21, Downview Road, Yapton
Proposed Single Storey Side Extension
Application No. Y/86/17HH

Further to your letter dated 13th December 2017 I would confirm the following points.

No. 62/17/03

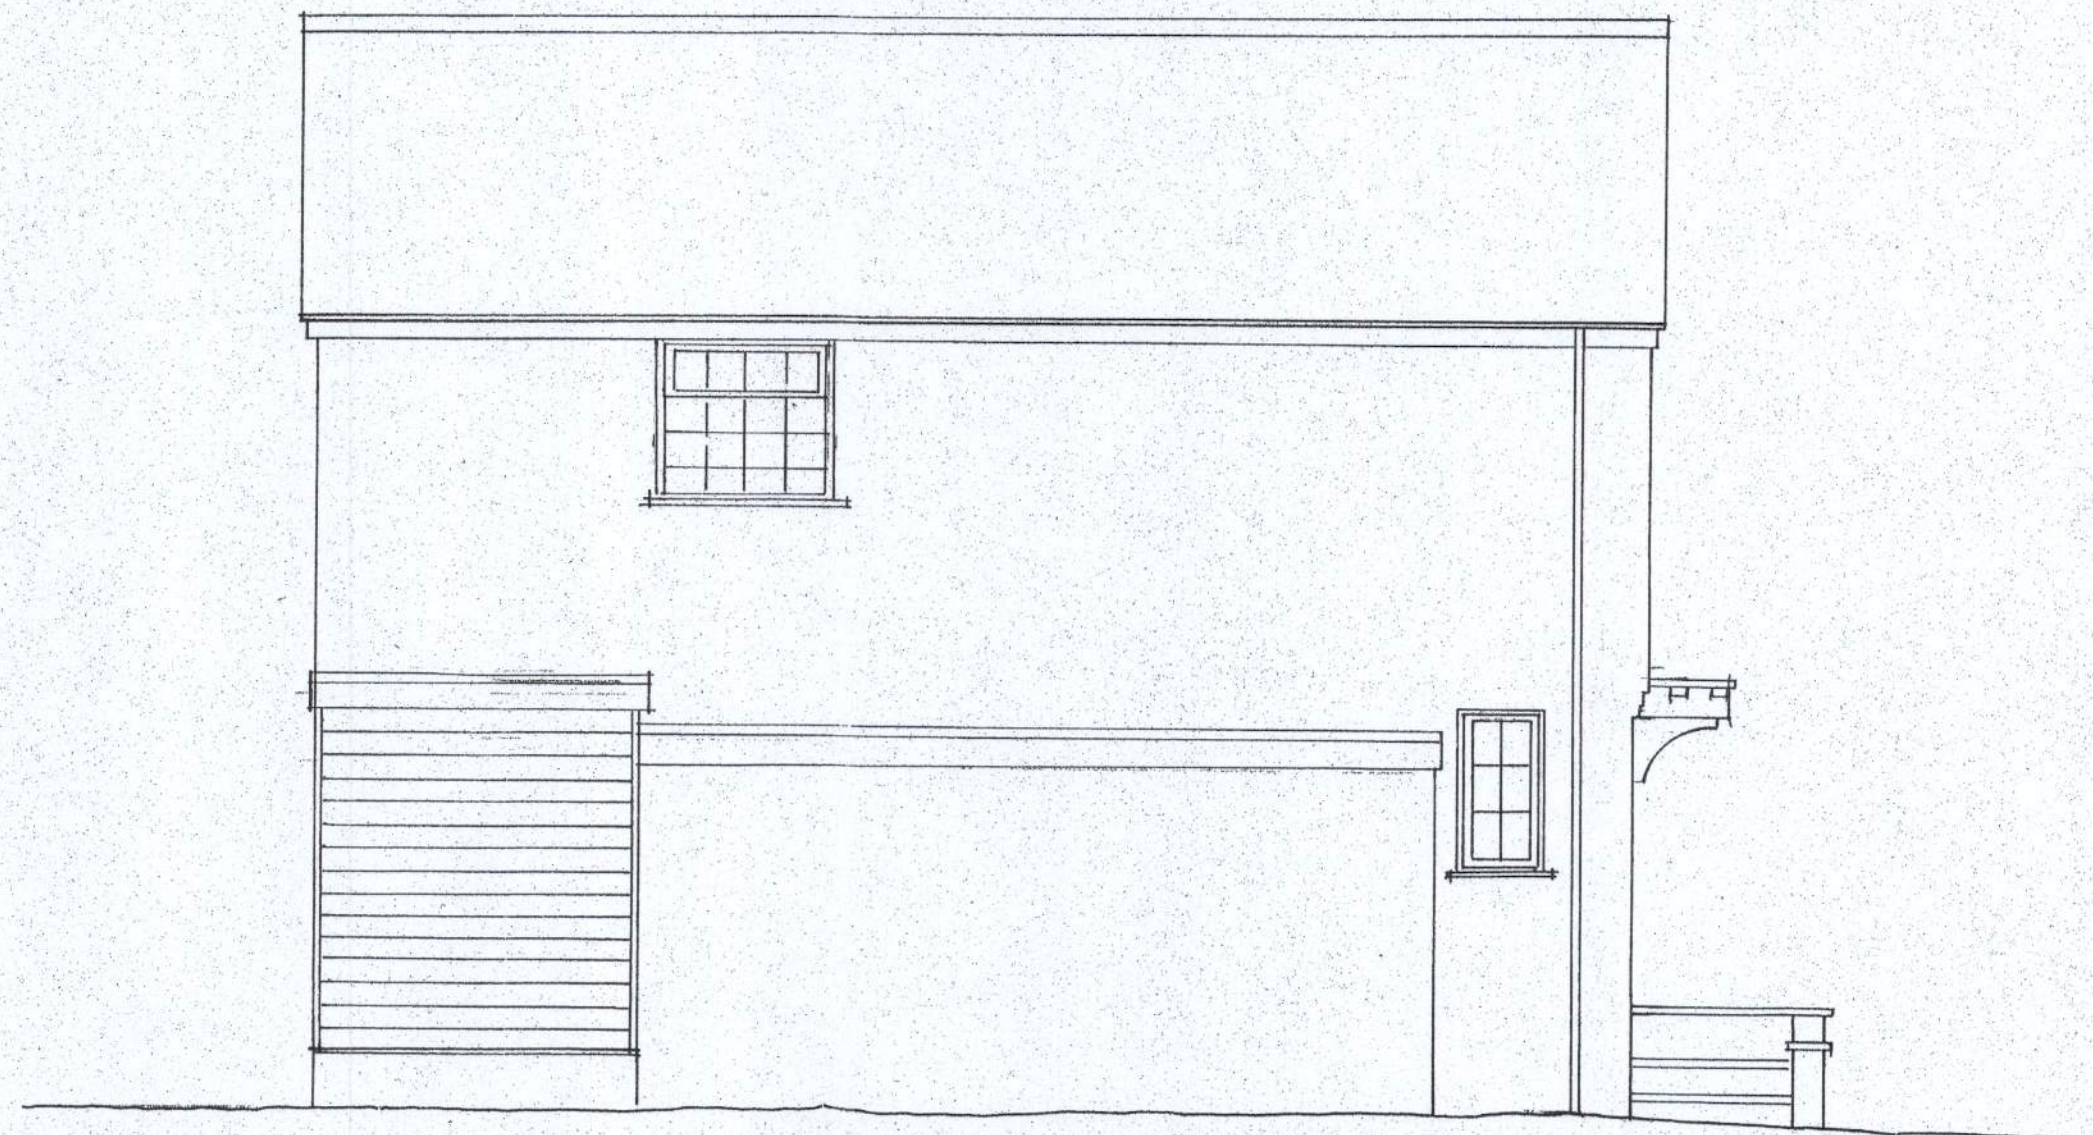
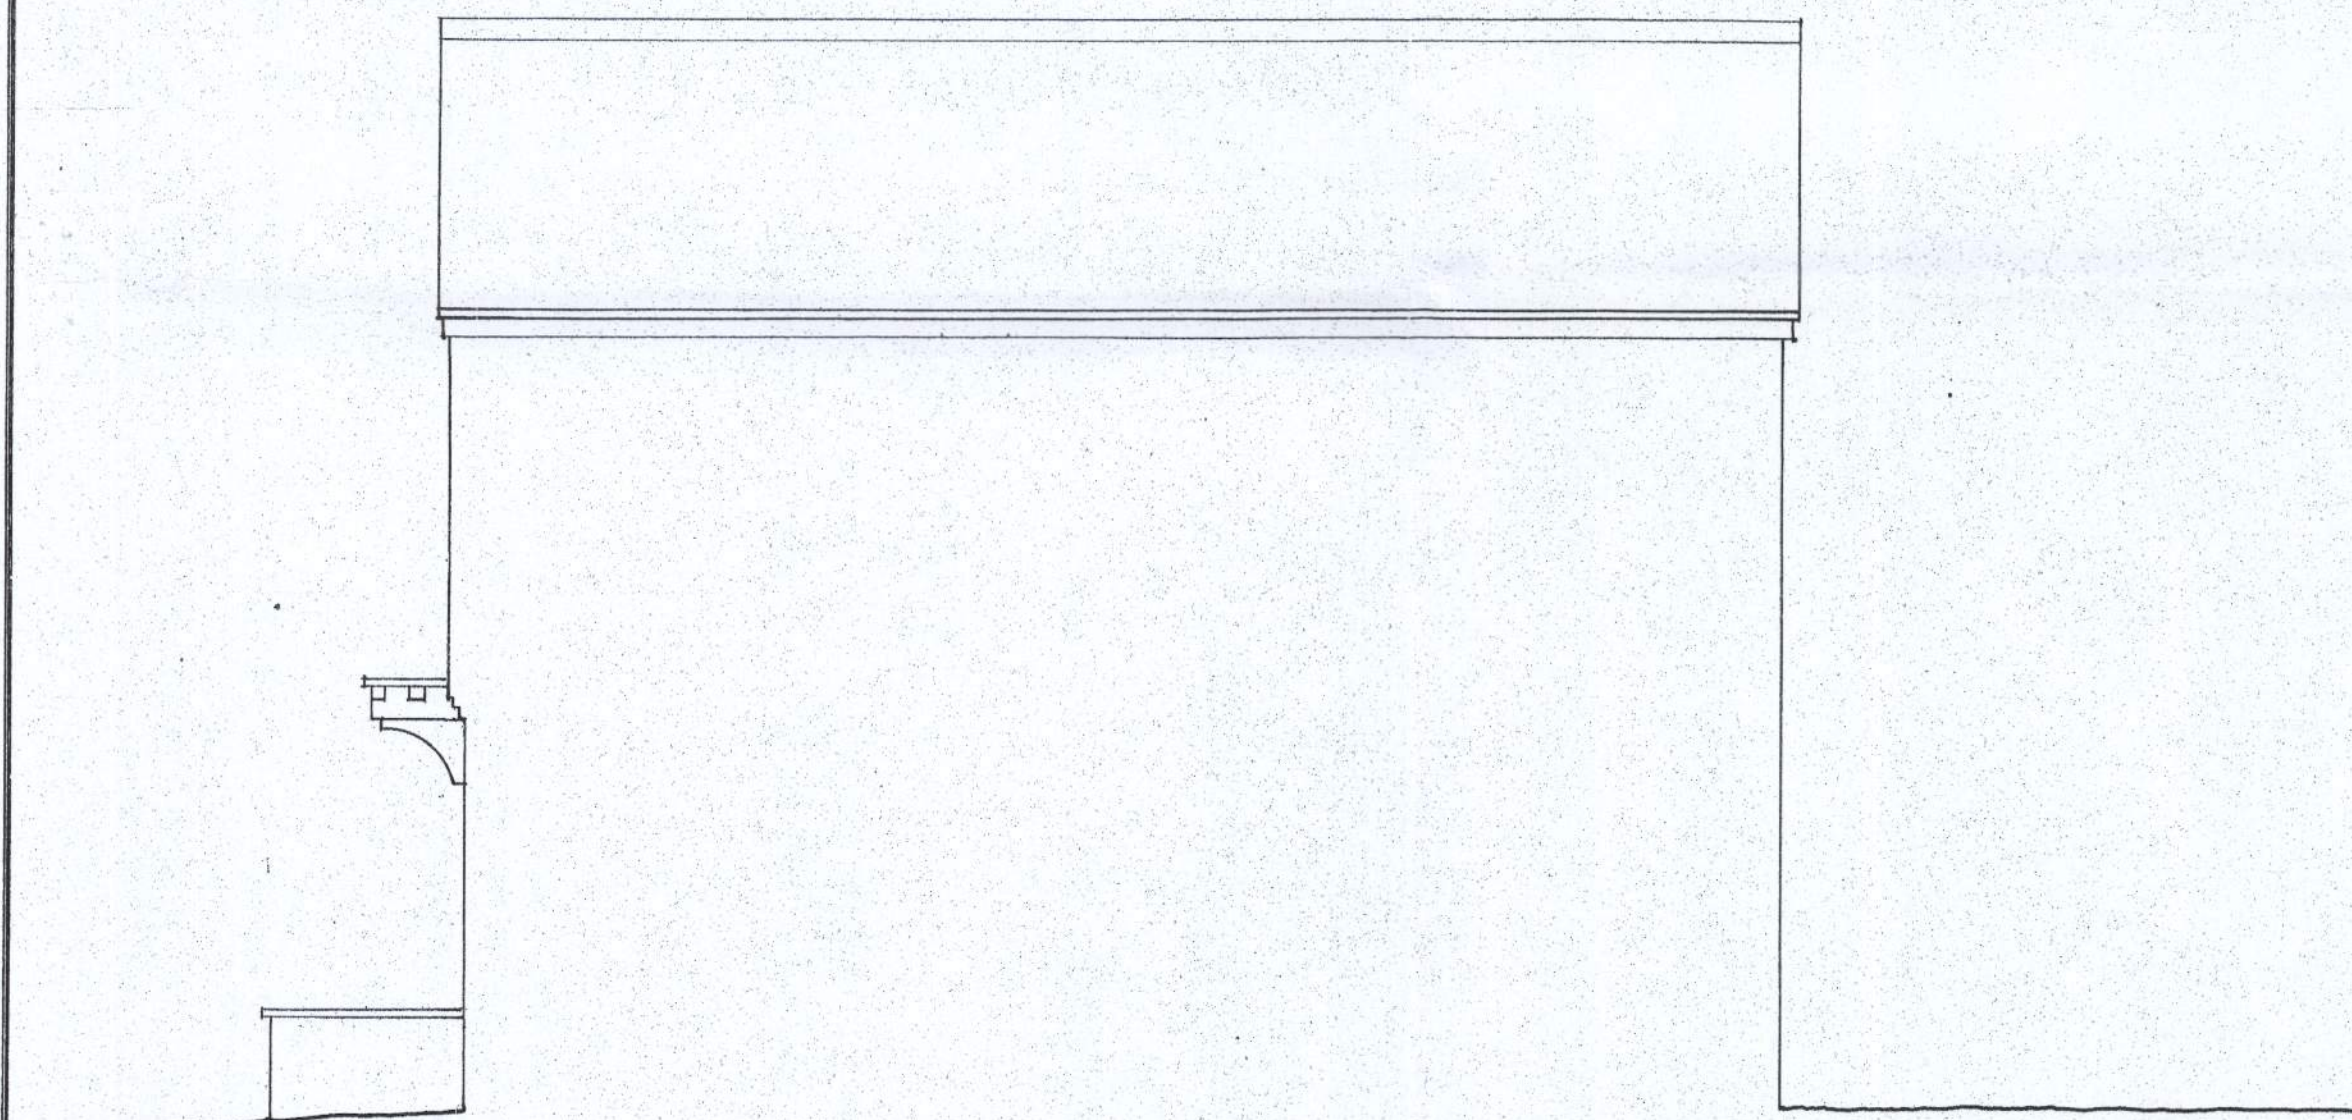
- 1) Two amended copies of my Drawing No. 62/17/03 showing the correct side elevation as requested.
- 2) The proposed scheme allows for the new WC, wash basin & any utility room fittings to be connected to the existing Soil & Vent pipe so there will not be a requirement to make a new foul water drainage connection.
